<p>Attention Director Application Number: SSI 7485</p> <p>Infrastructure Projects, Planning Services, Department of Planning and Environment GPO Box 39, Sydney, NSW, 2001</p> <p>Application Name: WestConnex M4-M5 Link</p>	<p>Name: <u>Penny Mburu</u></p> <p>Signature: <u>[Signature]</u></p> <p>Please <u>include</u> my personal information when publishing this submission to your website. I <u>HAVE NOT</u> made reportable political donations in the last 2 years.</p> <p>Address: <u>14 ere so</u></p> <p>Suburb: <u>Newtown</u> Postcode <u>2042</u></p>
---	--

I object to the WestConnex M4-M5 Link proposals for the following reasons:

Figure 10-16 Highly noise affected residential receivers - Darley Road

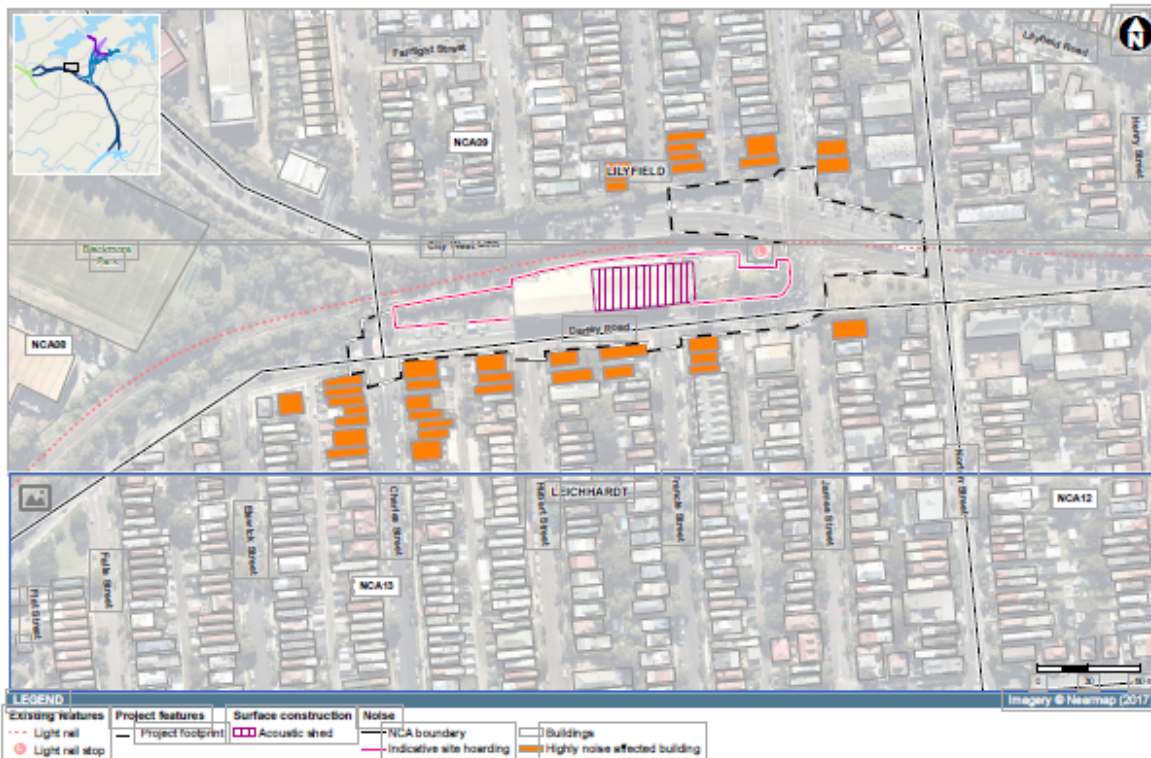
- 371 homes and hundreds of residences near the Darley Rd construction site will be affected by noise sufficient to cause sleep disturbance. The EIS promises negotiation over mitigation on a one by one basis. This is not acceptable to me. On other projects those with less bargaining power or social networks have been left more exposed. There is no certainty in any case that additional measures would be taken or be effective. This is another unacceptable impact of this project and reason why it should be opposed.

- ❖ I am appalled to learn that more than 100 homes including hundreds of residents will be affected by noise exceedences 'out of hours' in the vicinity of Darley Road, Leichhardt. This will not just be for a few days but could continue for years. Such impacts will severely impact on the quality of life of residents.
